From: [REDACTED]
Sent: 29 June 2026 08:21
To: Planning
Subject: Planning Application 3/2026/0354

I strongly object to planning application 3/2026/0354.

The proposed two-storey side extension would cause clear and unacceptable harm to neighbouring residential amenity, directly conflicting with Policy DMG1 of the Ribble Valley Local Plan and paragraph 135 of the NPPF (2023).

Notes
This drawing is the property of IDC Home Architecture Ltd and copyright is reserved by them. This drawing is not to be copied or disclosed by or to any unauthorised persons without the prior written consent of IDC Home Architecture Ltd.

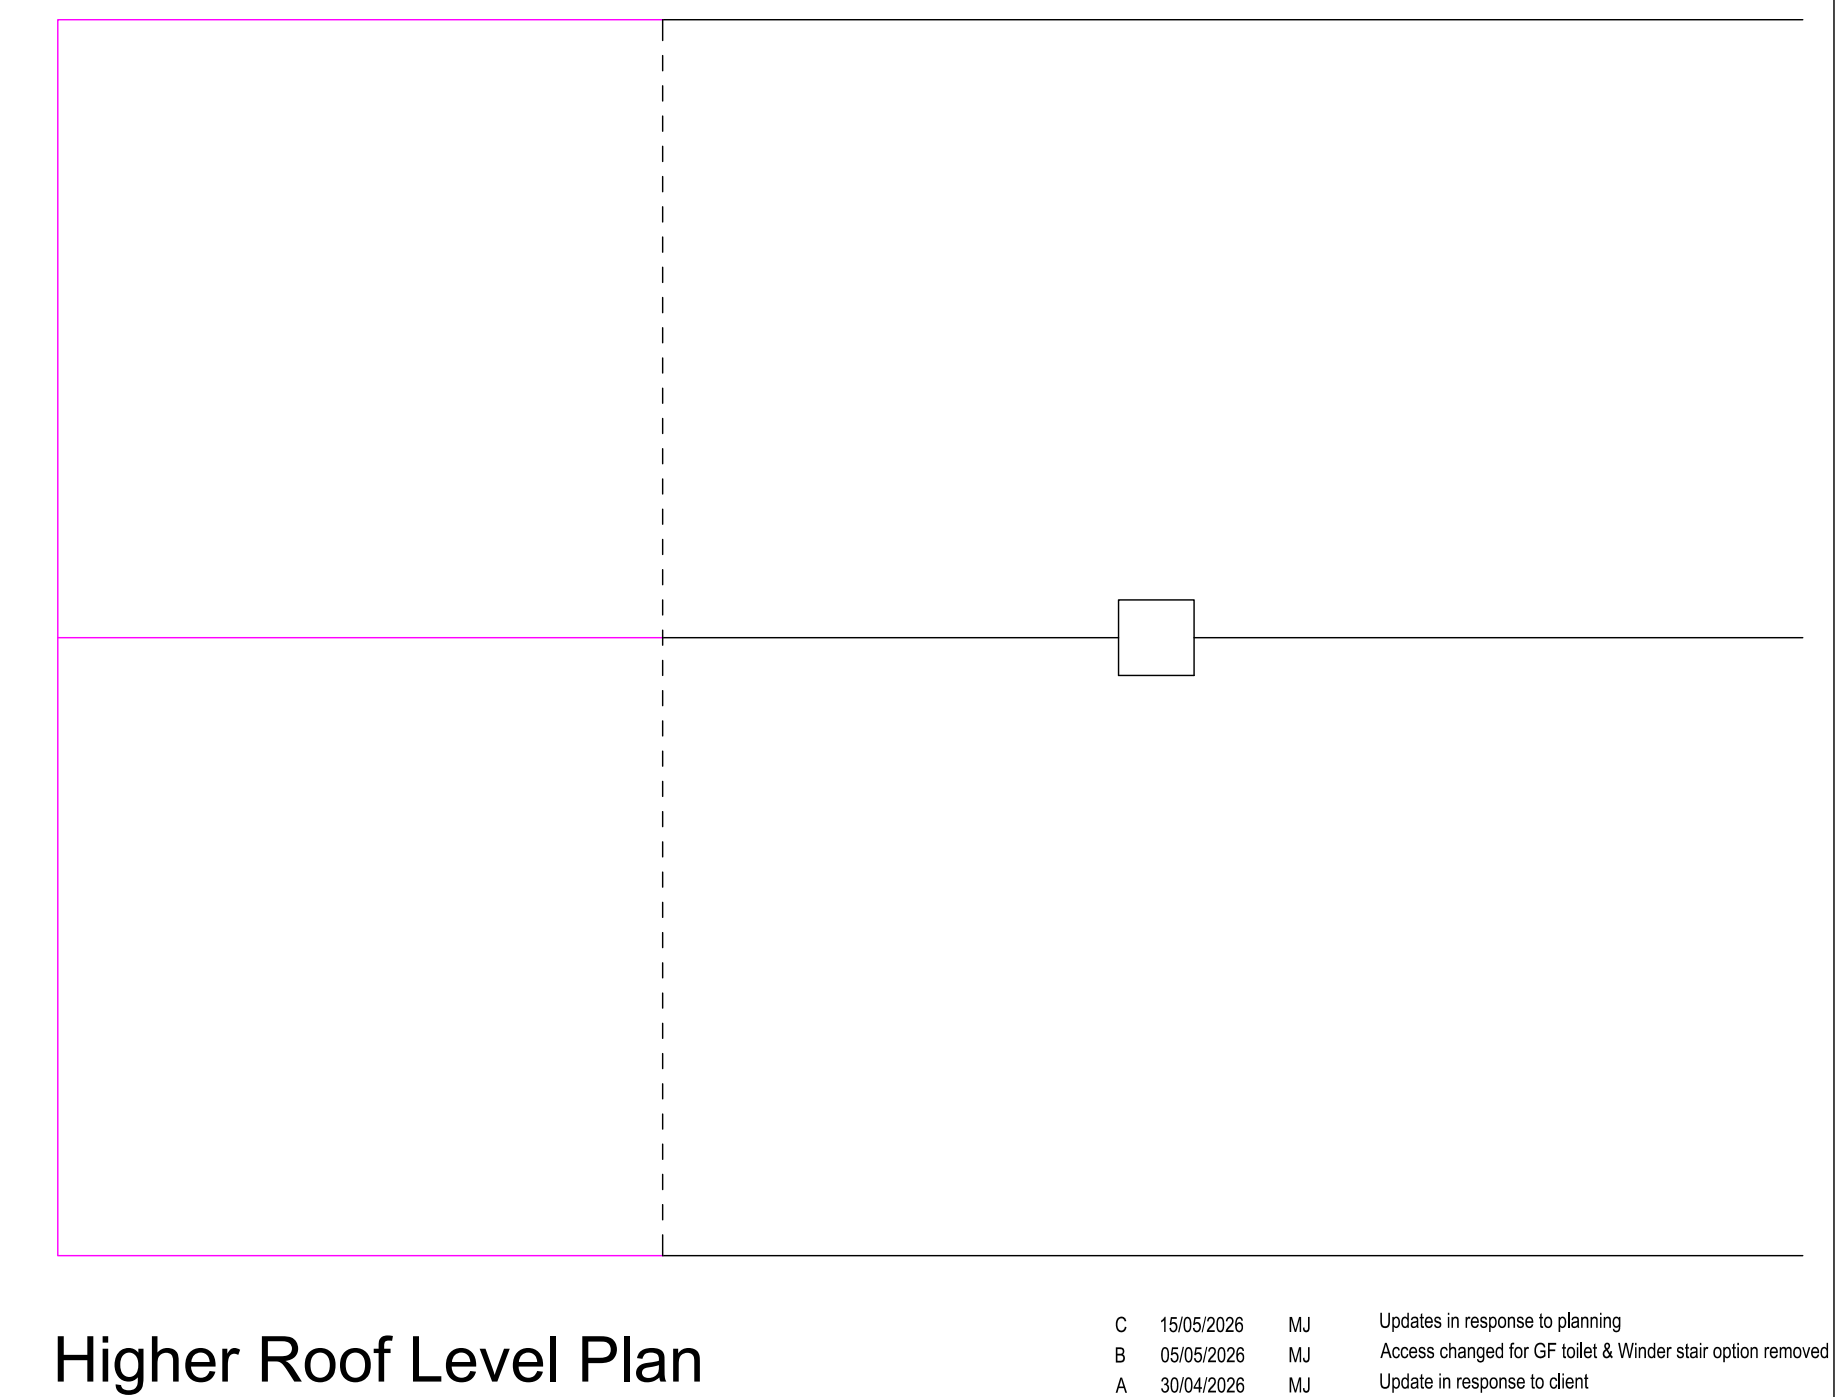
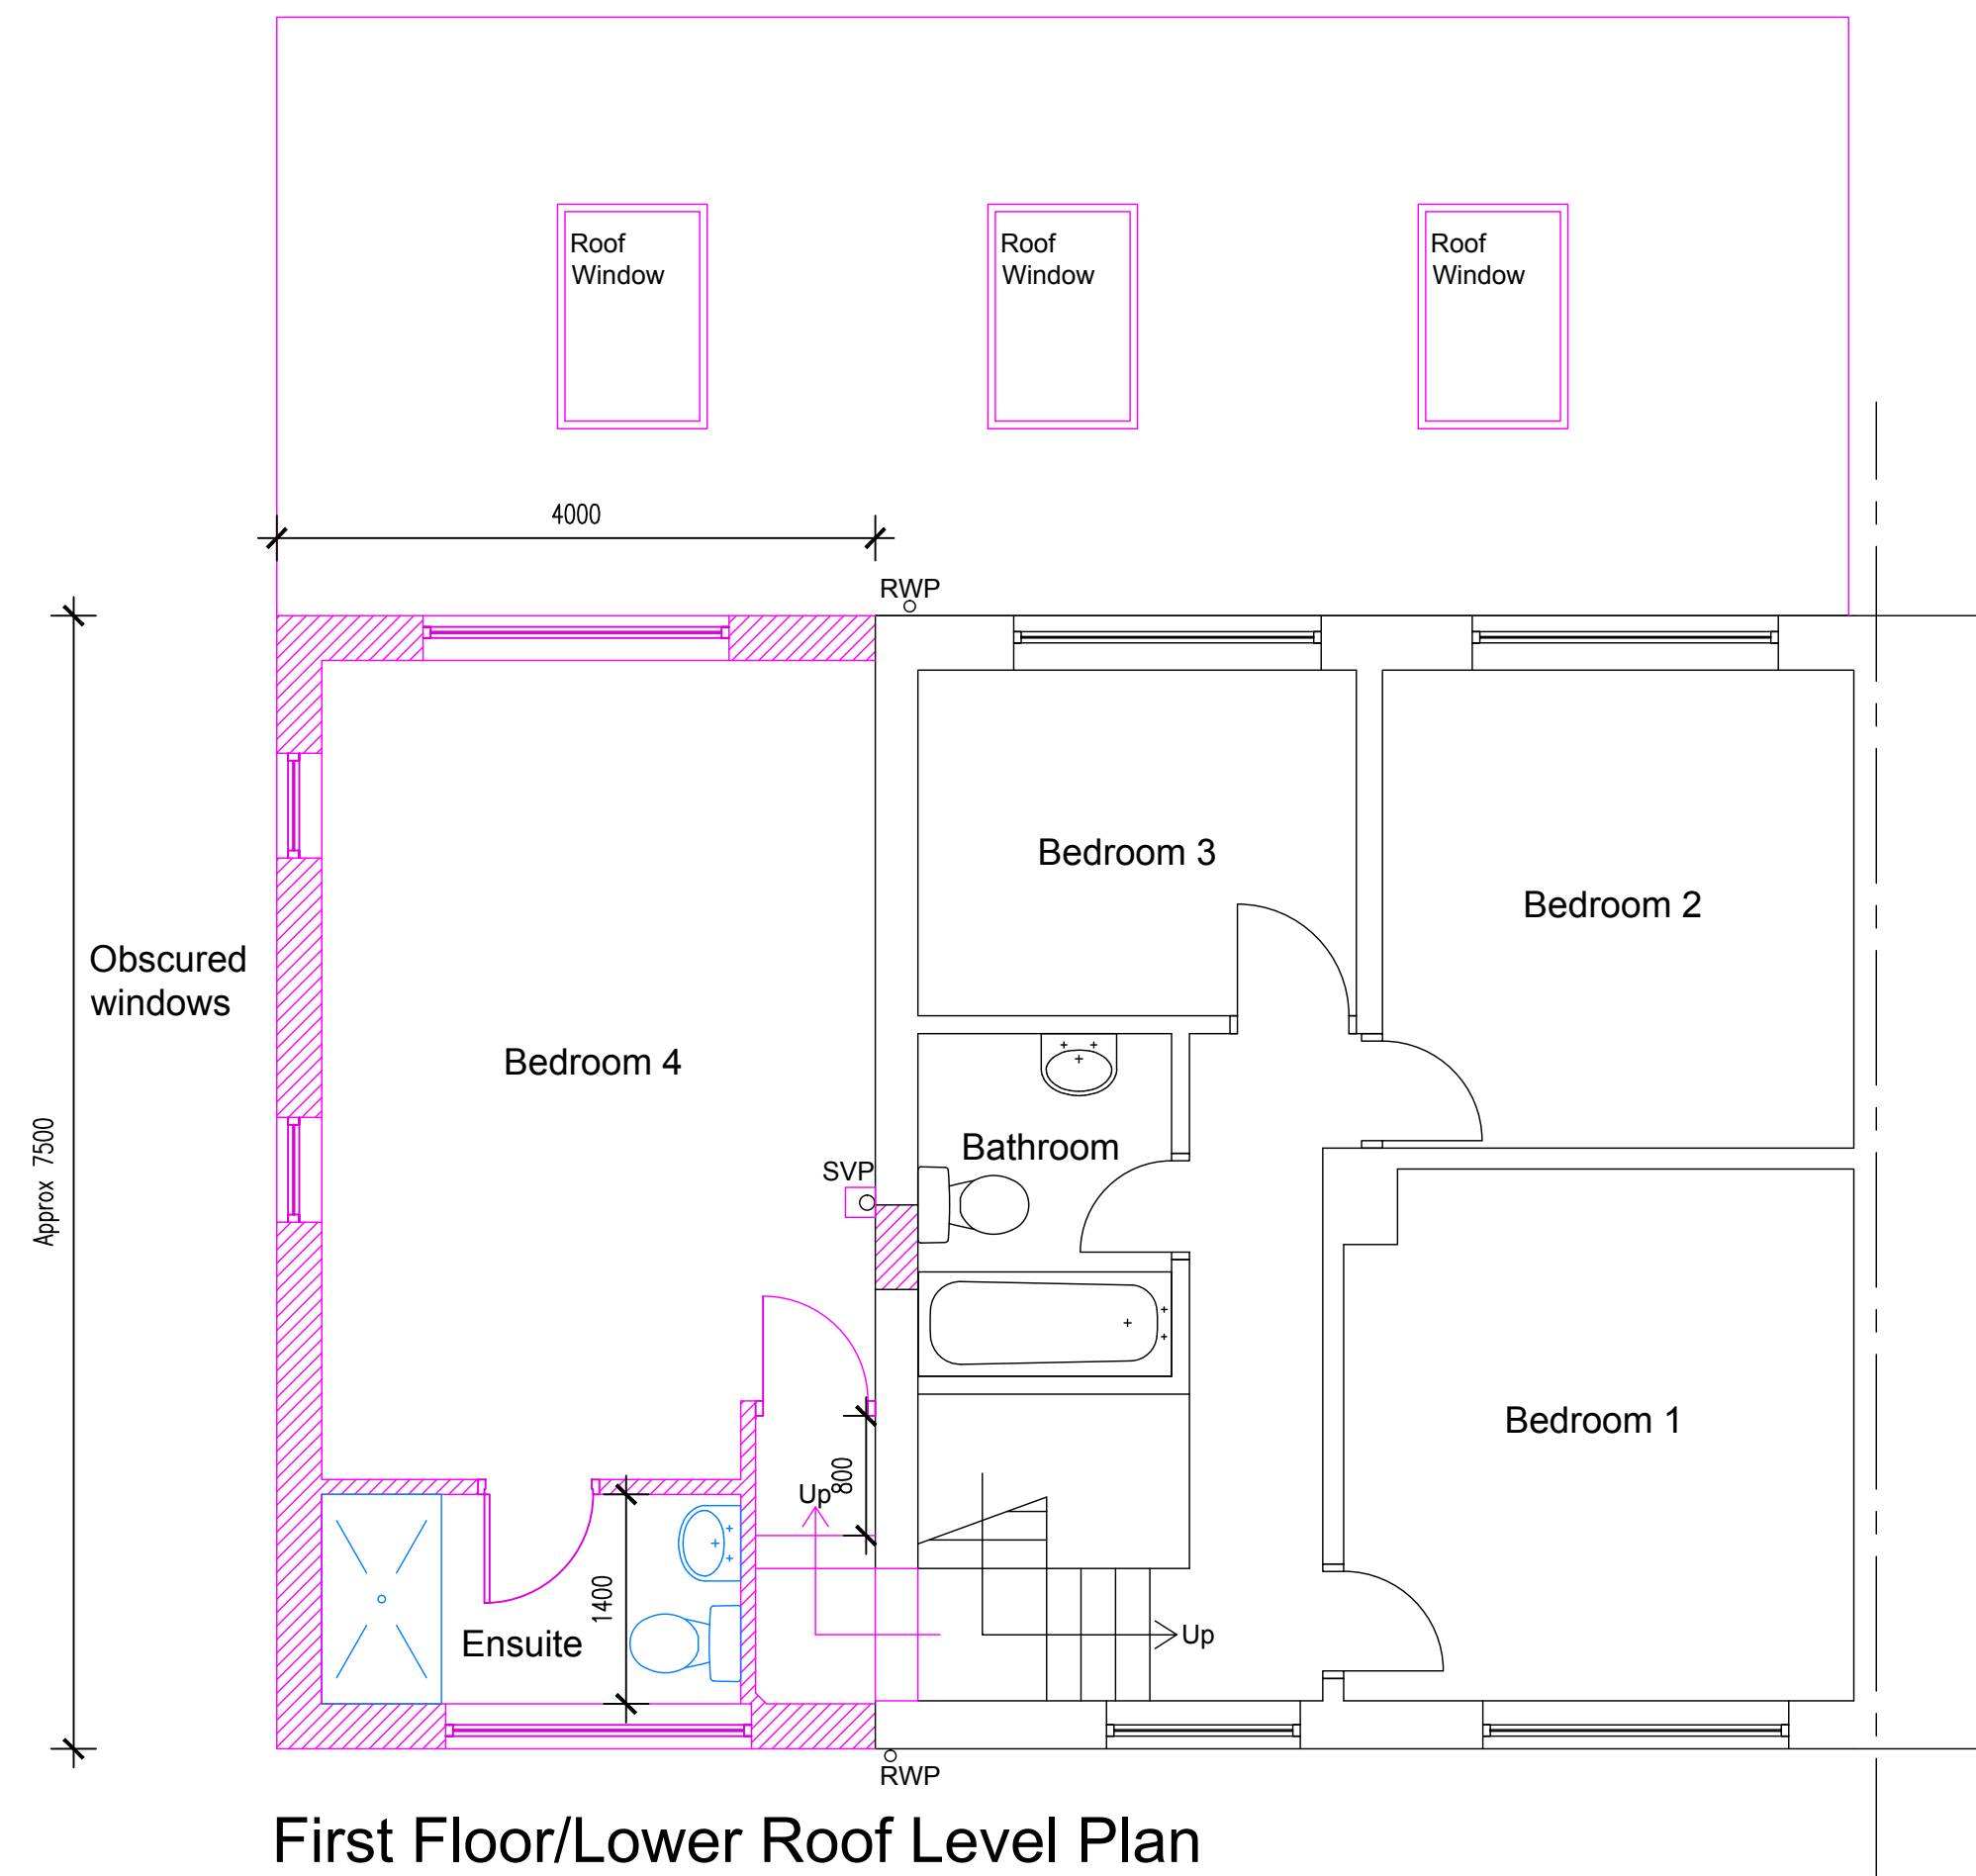
Most significantly, the inclusion of large first-floor side-facing windows is wholly unjustified and unacceptable. These openings, even if obscure-glazed, would directly face neighbouring private garden spaces and introduce an intrusive and overbearing element. Their excessive size further exacerbates this issue and creates an unnecessary and avoidable risk of overlooking.

Secondly the use of full height windows to side elevation seems both intrusive to the adjacent dwelling and also unnecessary in respect that the other extended accommodation on the similar houses have no glazed windows whatsoever to the side elevation. Also seems preposterous to have an unfrosted window in what is to be an ensuite bathroom at the front of the proposed extension.

In addition to these points using the boundaries highlighted in the location plan, given scales and the existing dimensions alongside the proposed dimensions it appears the proposed extension at an overall width of 10.5M is to be either on or extremely close to the boundary of the adjacent property. This would therefore create a both dominant and intrusive structure, not to mention the lack of access to maintain or construct the extension in the first instance. Its my understanding that in accordance with the access to neighbouring land act 1992 any access required for scaffolding, construction or future maintenance such as soffits, guttering or rendering would need to be sought from the occupiers of the adjacent property and that would be categorically denied.
